9 November 2022

Ms Nicole Brewer Director, Energy Assessments Development Assessment Department of Planning and Environment Locked Bag 5022 Parramatta NSW 2124

Submission in Response to the EIS on the Proposed Birriwa Solar Farm (Application No SSD-29508870)

C.1 Concept plan of road upgrade corridor

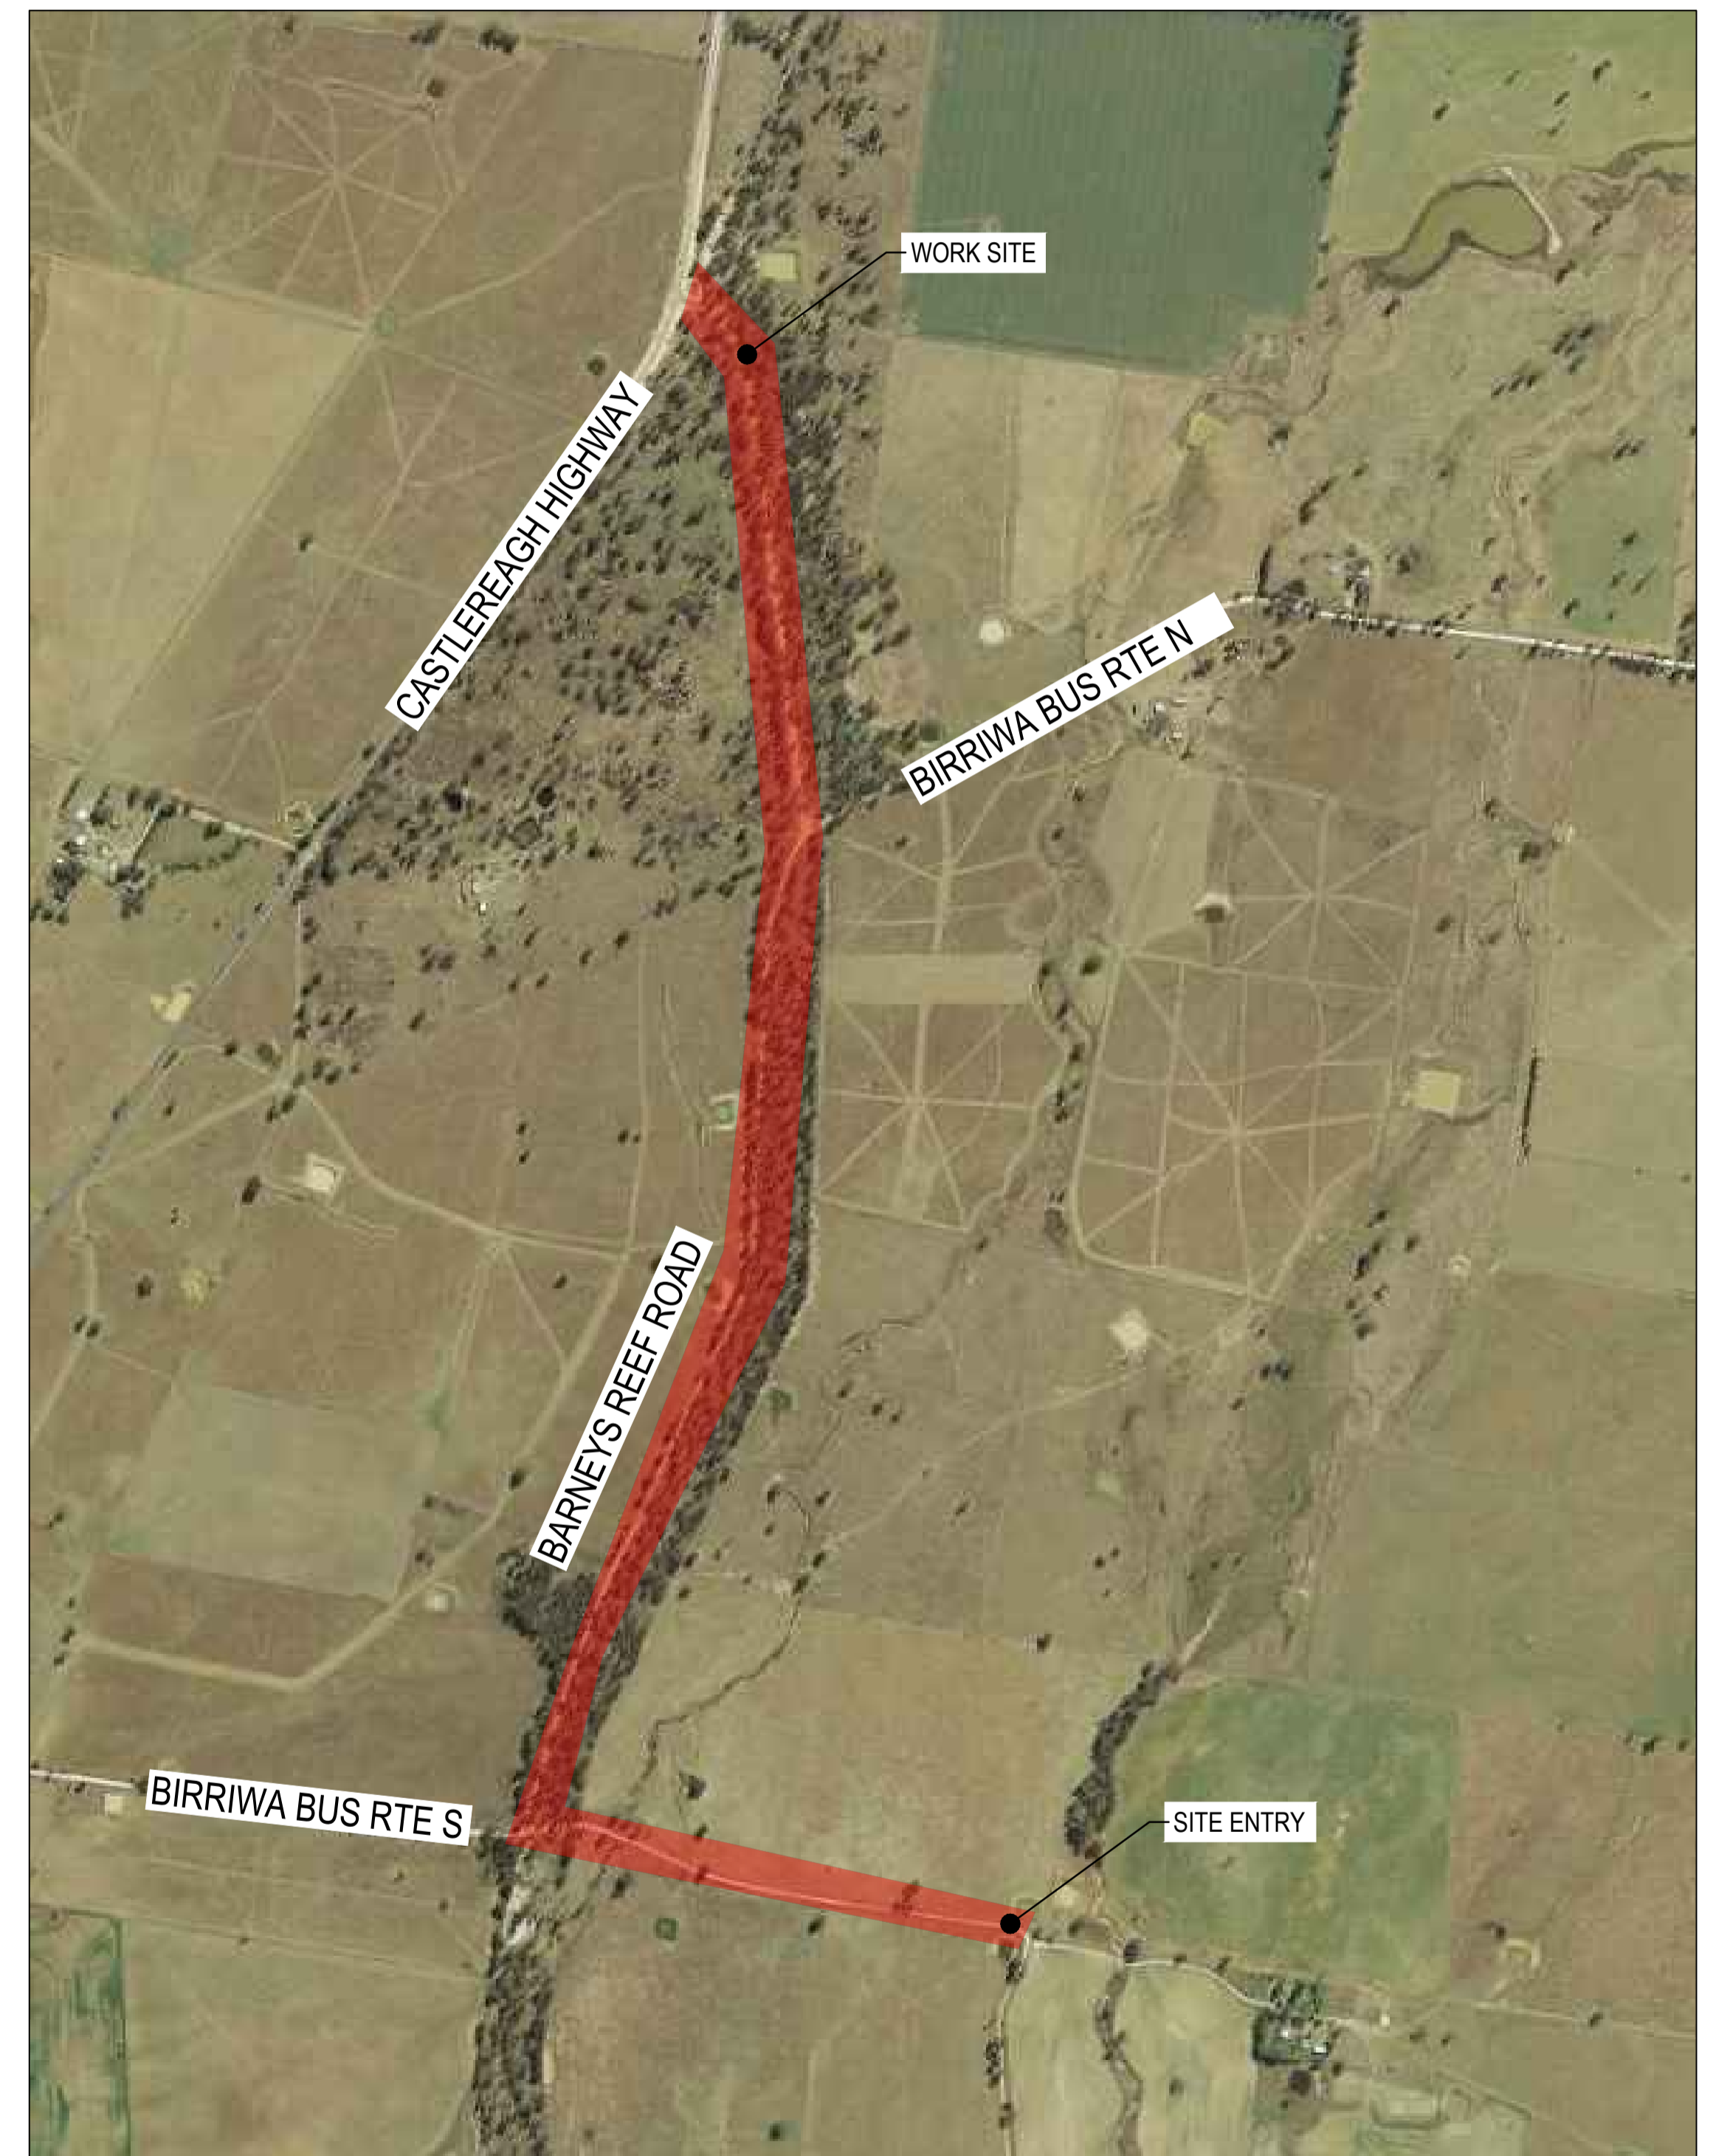
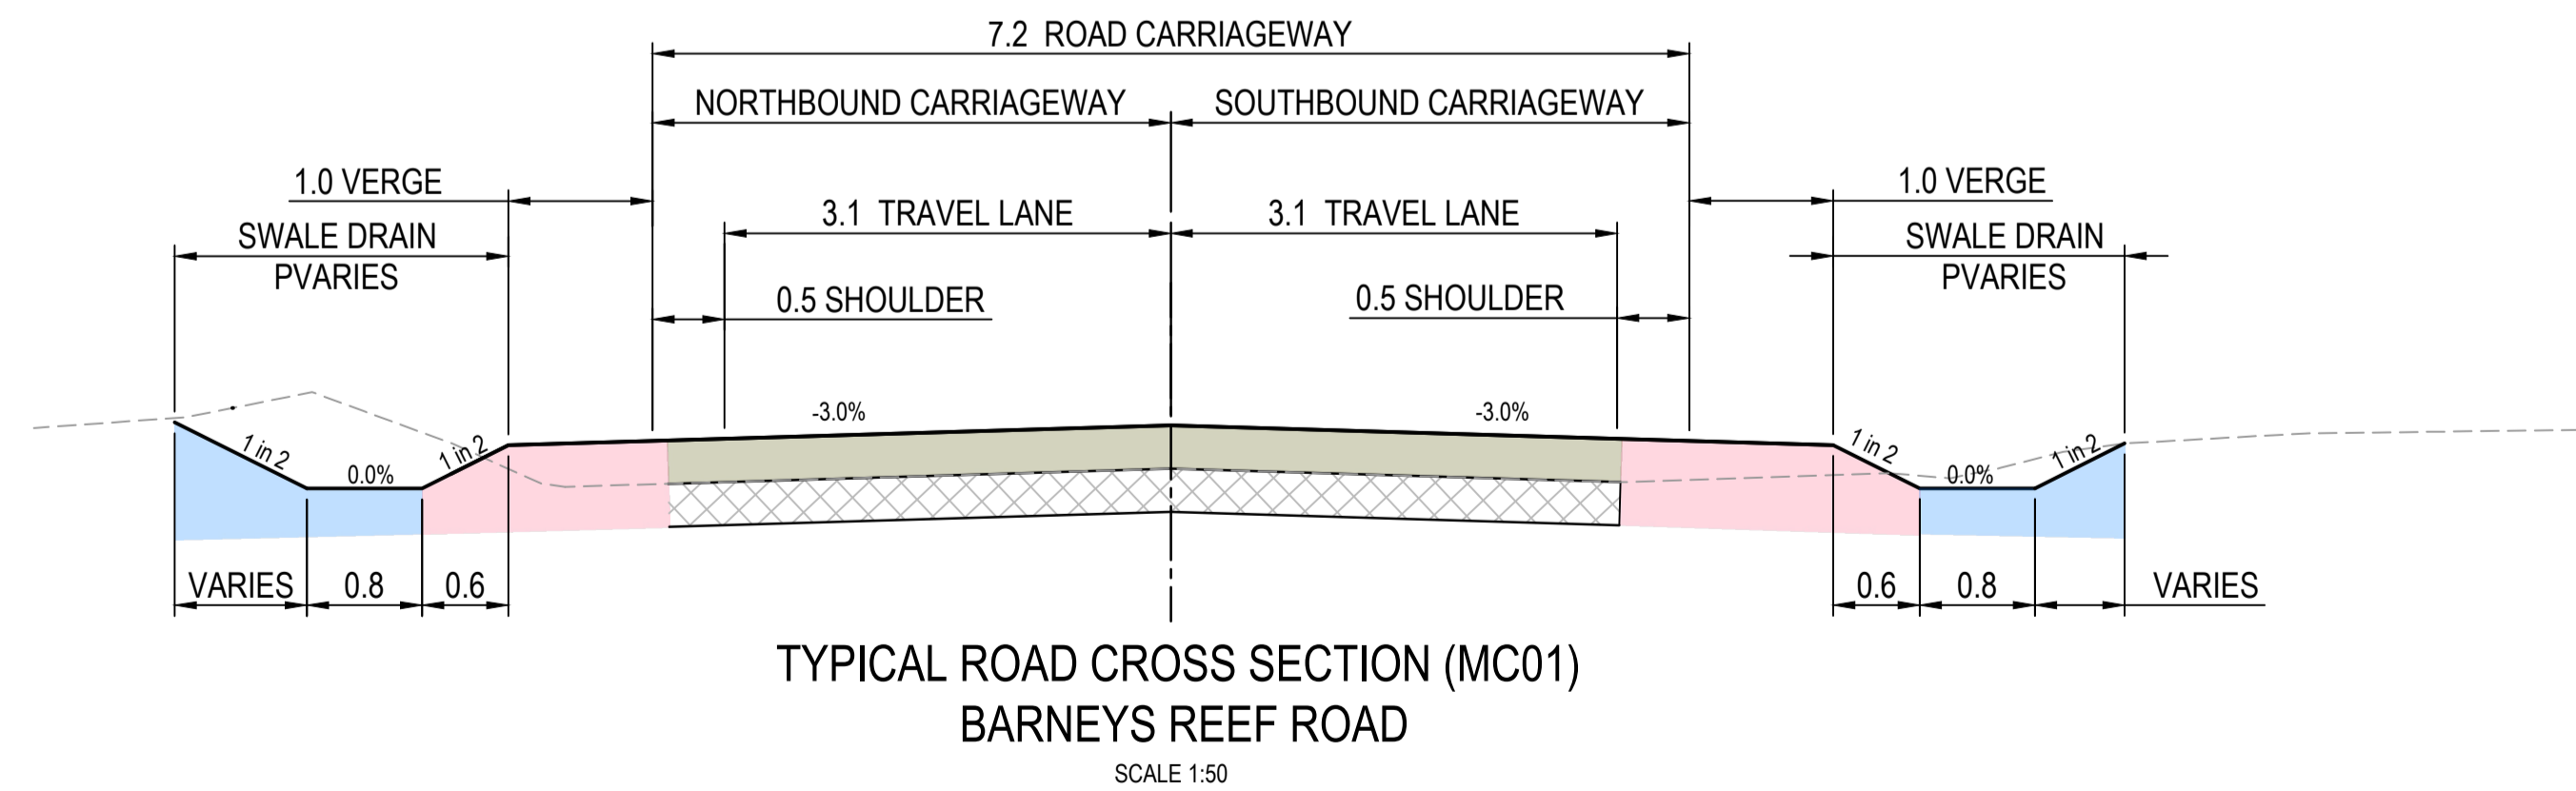
- Due to a narrow carriageway width of approximately 6 m, the unsealed Barneys Reef Road requires upgrading (resurfacing and widening) to a 9.2 m road carriageway (see ES5.3). However, there is confusion in the EIS as Table 3.3 (page 40) states an upgrade to a 7.2 m road carriageway (including 3.1 m travel lanes and 0.5 m shoulders). Please advise which is correct.

- The Developer is to maintain Barneys Reef Road at its cost and at a 'Good' Service Level or better in accordance with Council's Asset Management Plan (Roads), from the start until the end of the construction period, and repair and re-sheet the full width of the gravel base and wearing course to Council's satisfaction before handing back care and control to Council after decommissioning.
